Department of Transportation

November 2, 2020

RE: Waterview North Sketch Plan Amendment - 2020-SKP
Traffic Impact Study - CDOT review
Master Development Drainage Plan - CDOT review
Soil, Geology & Geo Hazard Report - CDOT review

PRE-DEVELOPMENT BASIN MAP

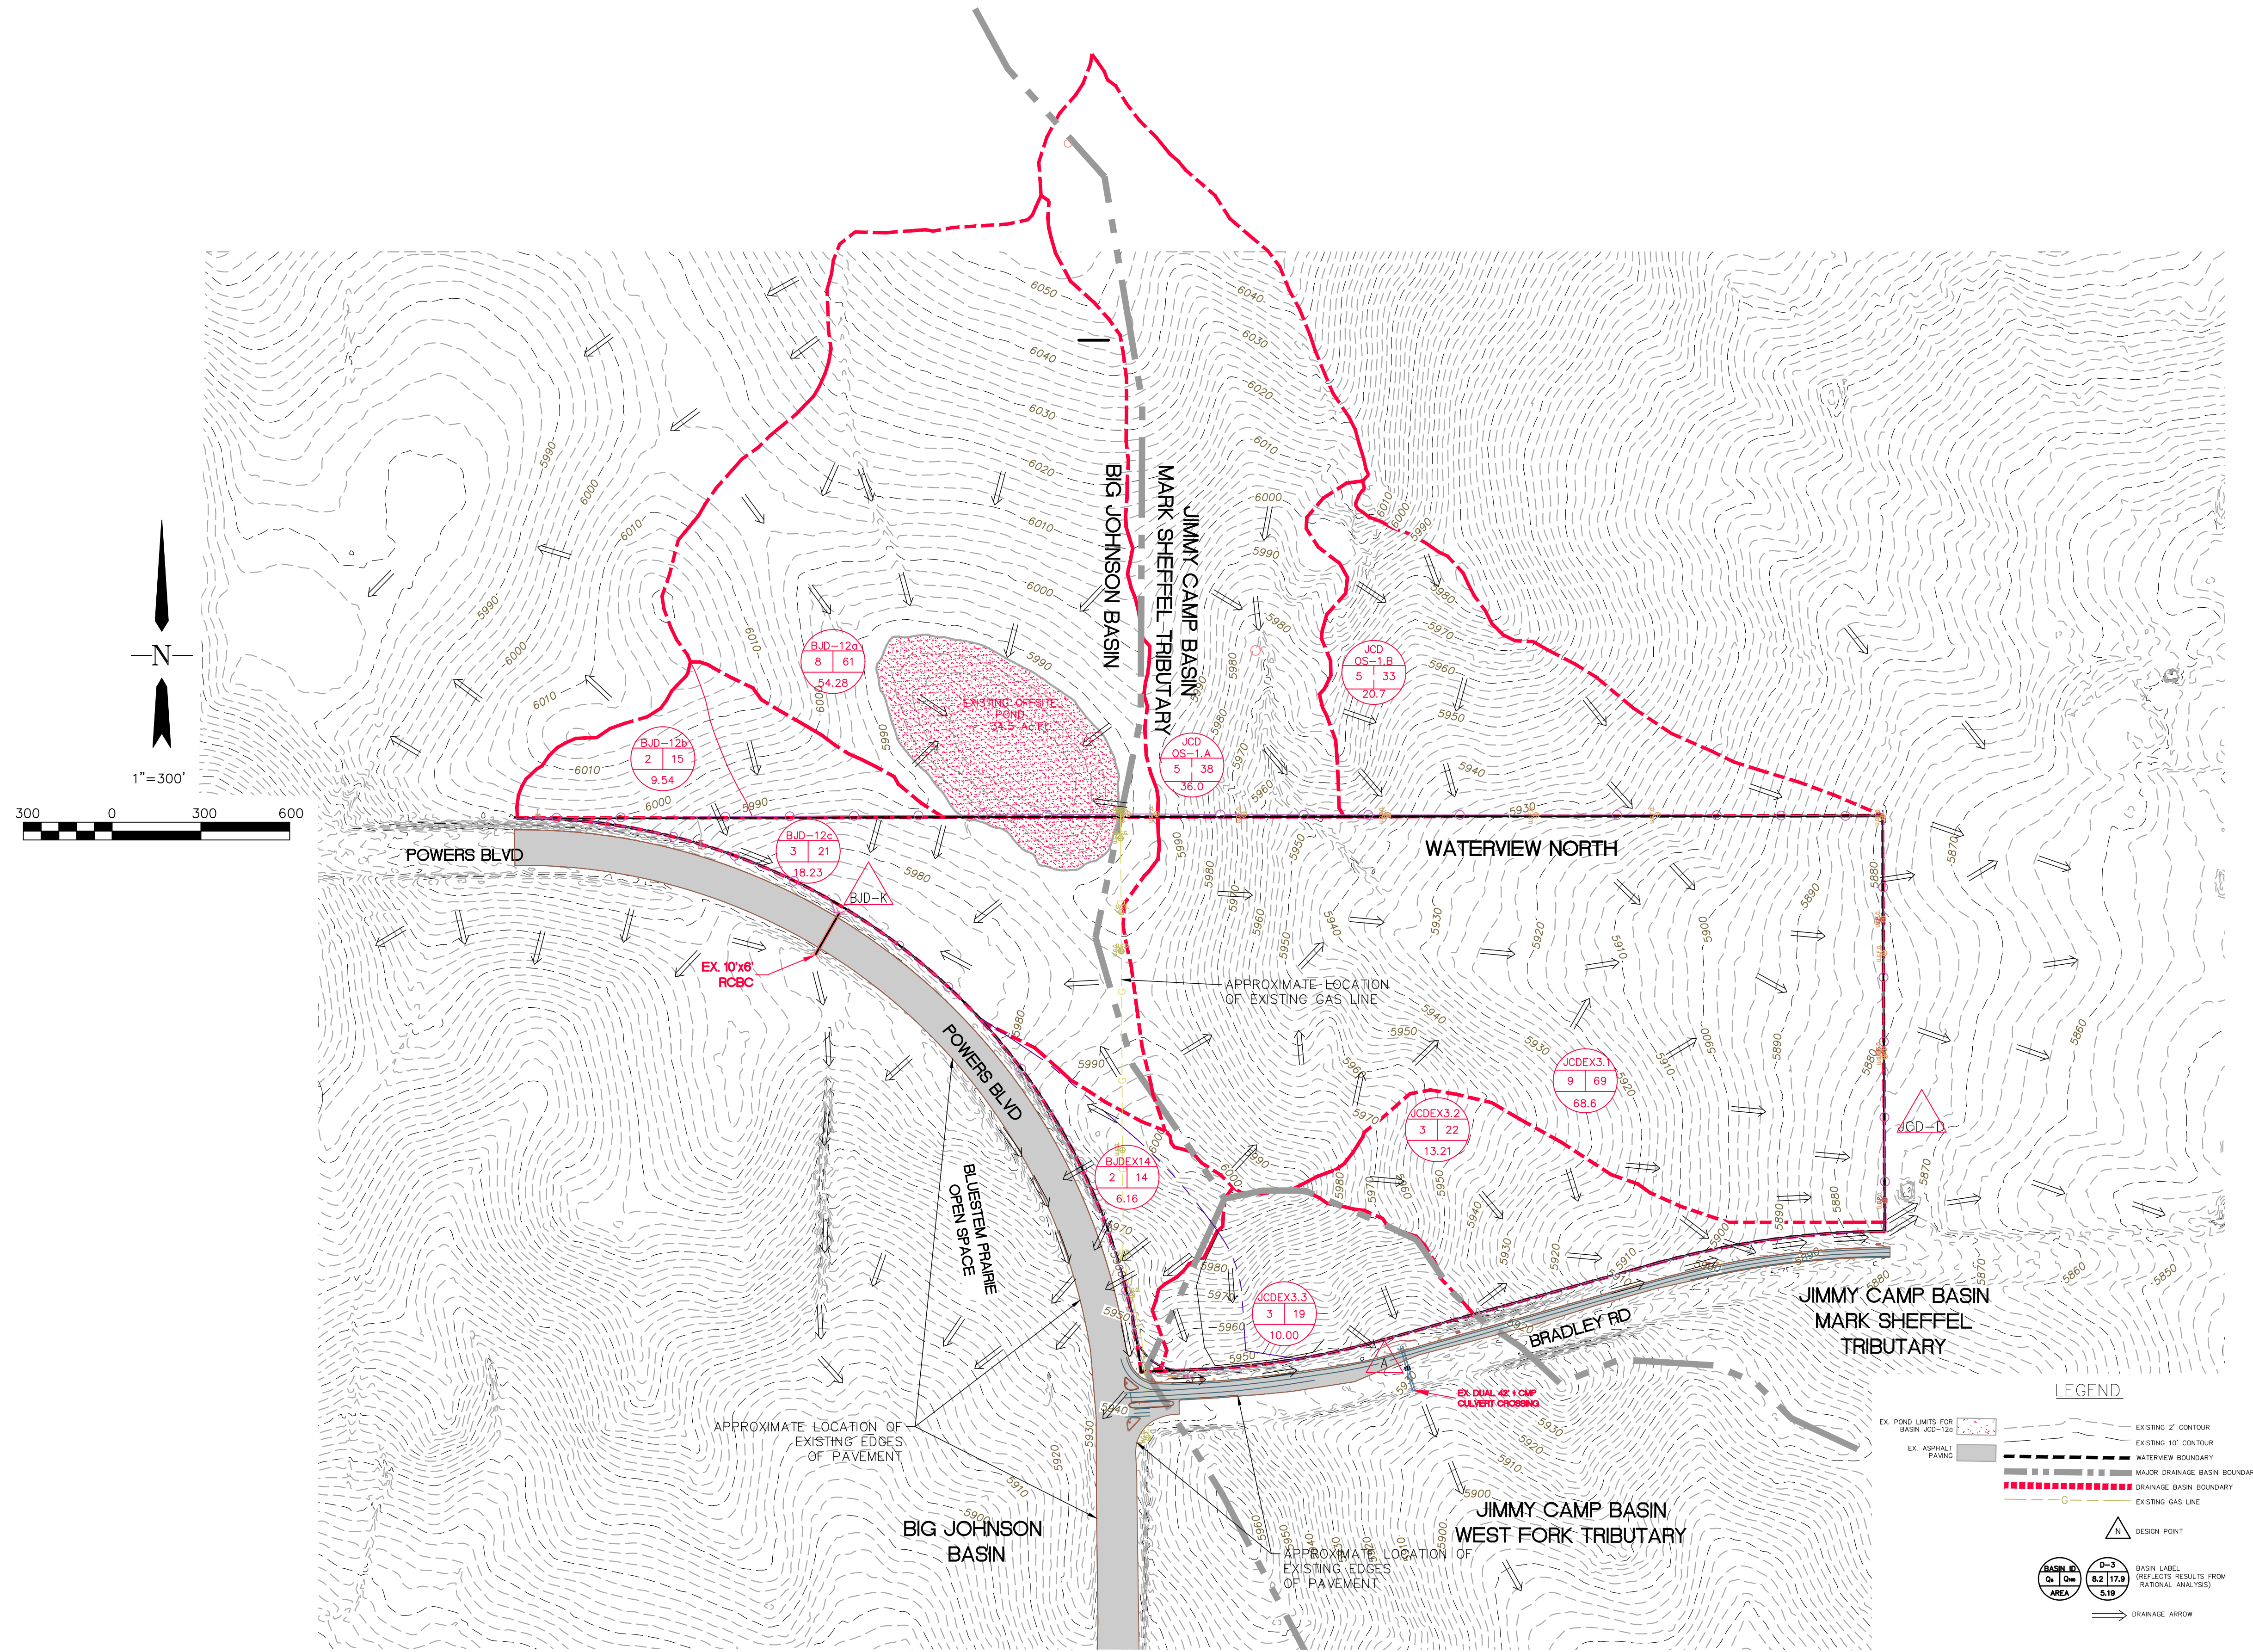
- The report refers to a local depression (34.5 ac-ft pond) in Basin BJD-12a, and states that because of this depression, no runoff from this basin makes its way to the culvert under Powers. What happens to water that gathers there in the existing conditions? This area looks dry from aerial photos, so the water has to go somewhere. With Powers being lower in elevation than this basin, please provide more assurances to CDOT that this 54.28-acre basin does not contribute to the flows at Powers as stated.

- Please review the basin delineation for BJD-EX14 and BJDEV14. It appears that there is a roadside ditch that carries runoff around the corner and then east along the north side of Bradley. The report states that this flow sheet flows over Powers Blvd. which is not the case.

POST DEVELOPMENT DRAINAGE PLAN

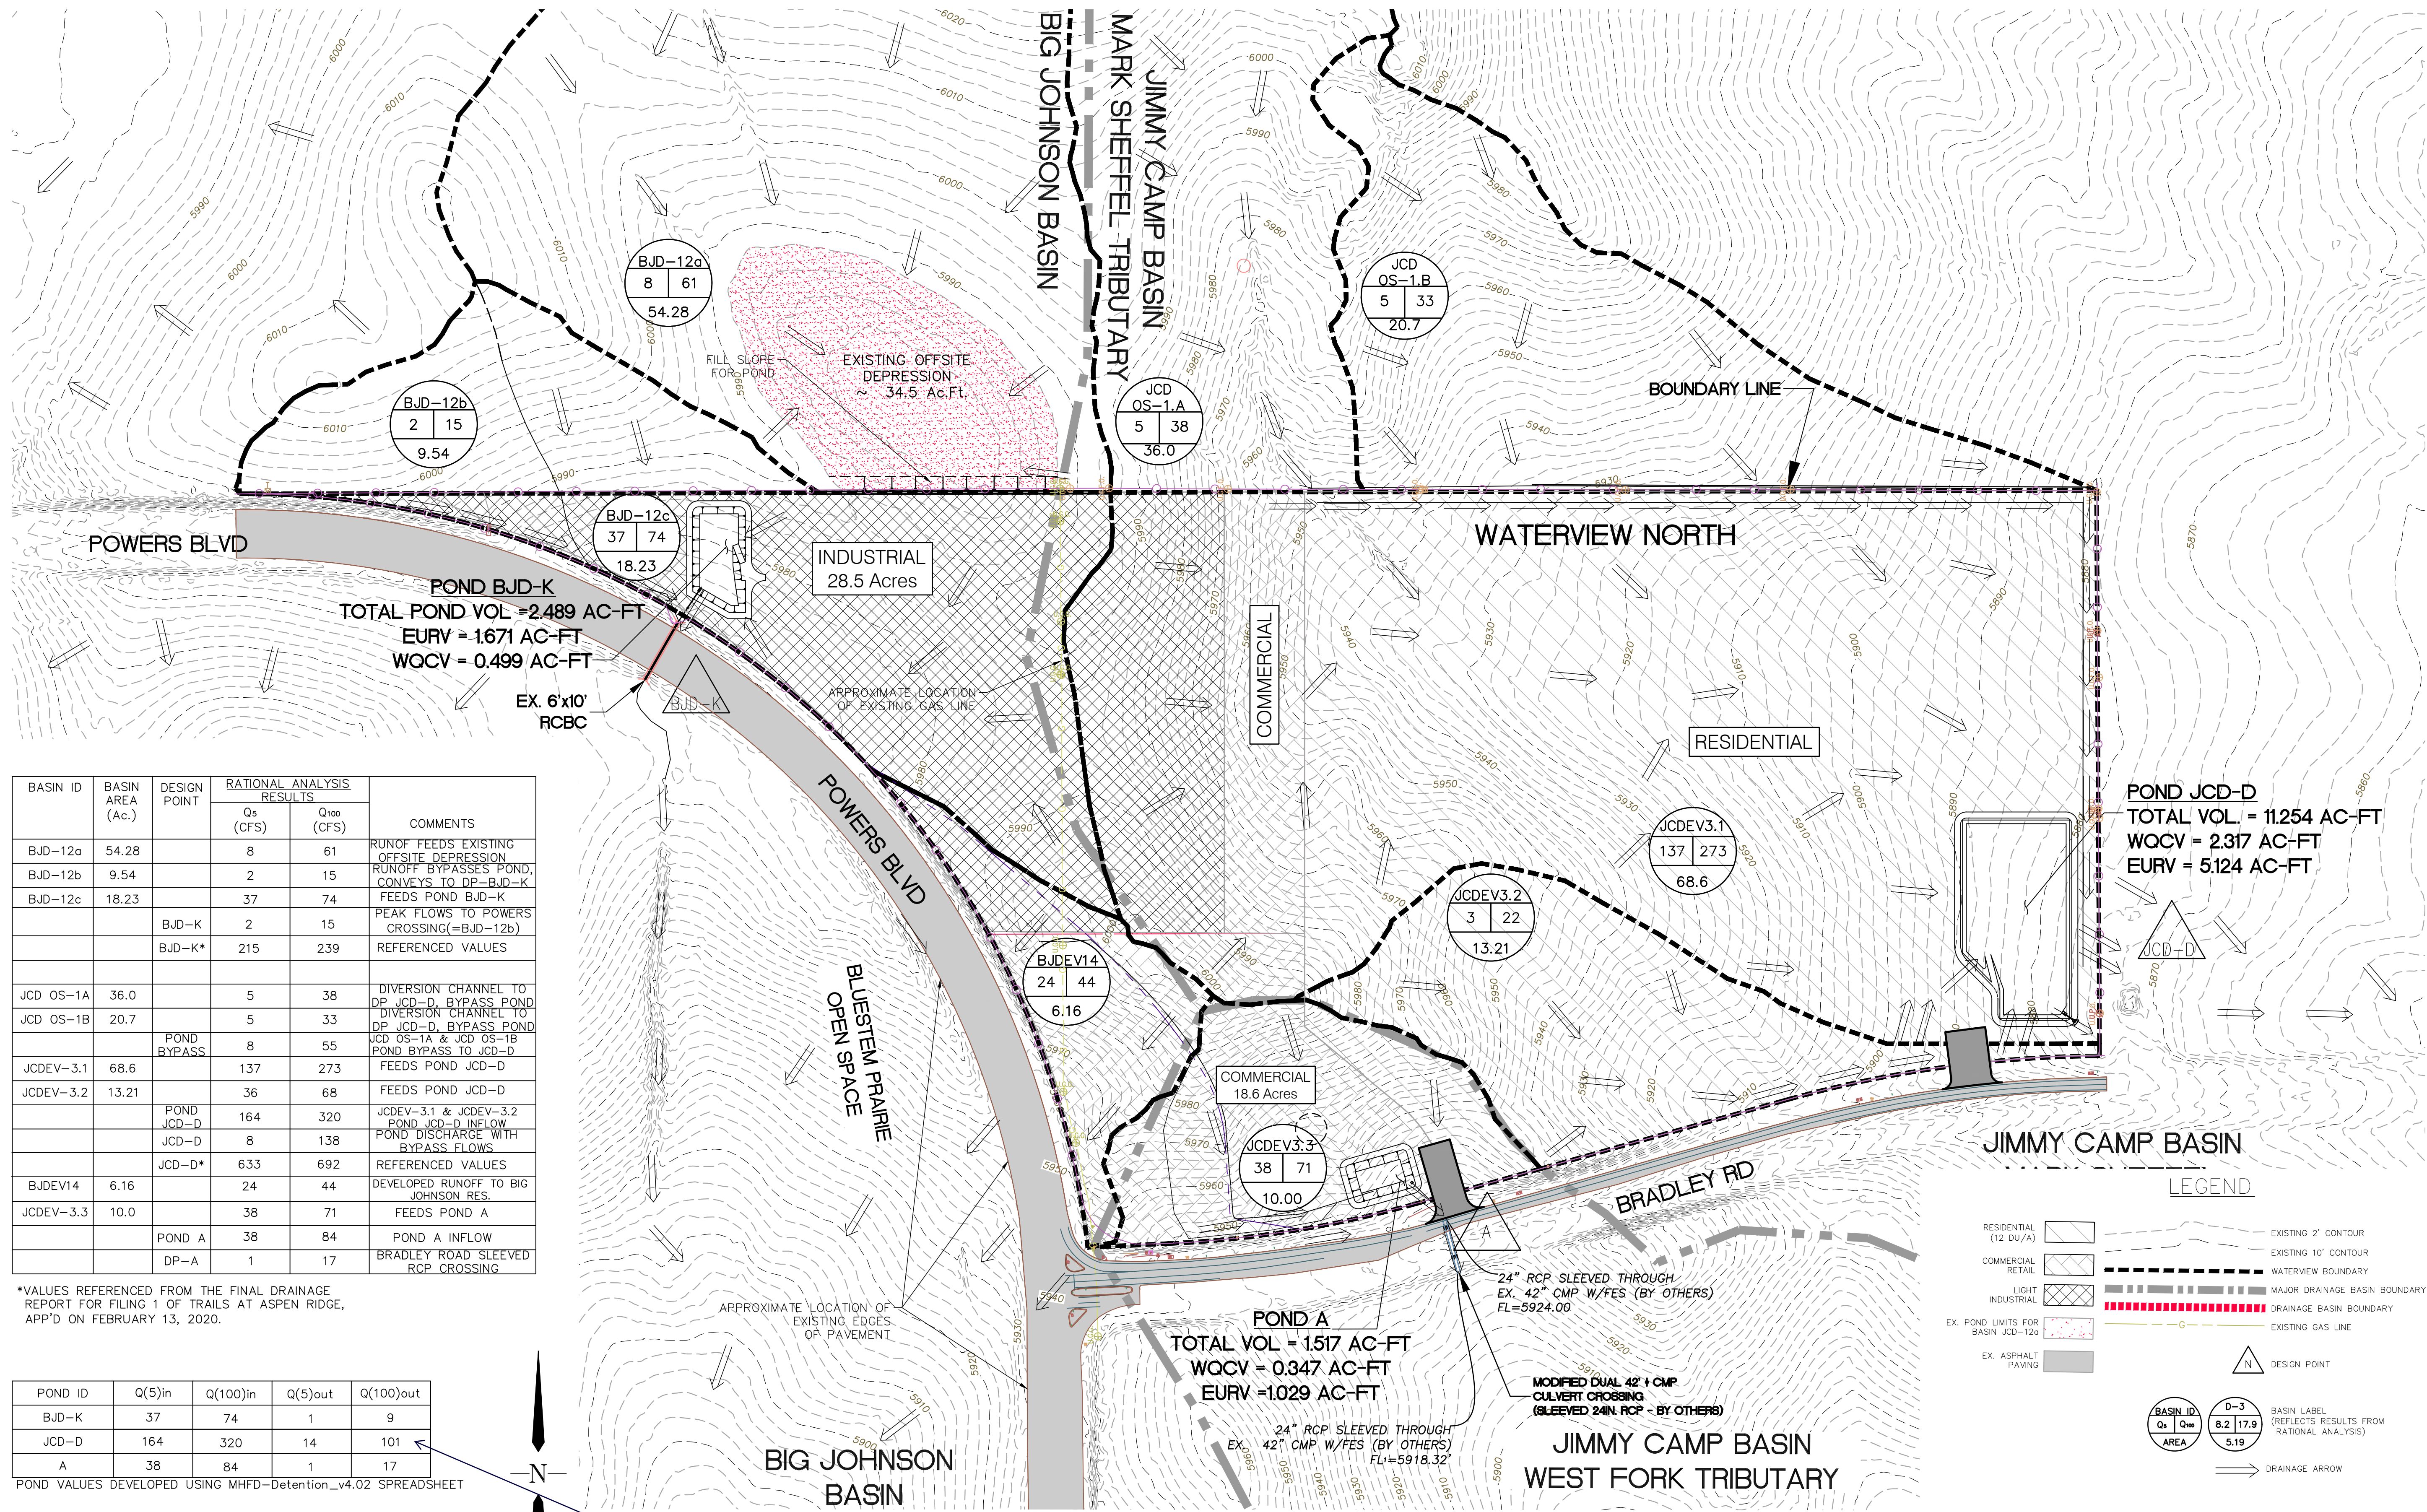
- Better define diversion channels 1 and 2 that are shown in the appendix in the drainage map.
- CDOT Materials Engineer has reviewed the Soil, Geology and Geologic Hazard report dated May 15, 2020 and their comments are as follows:
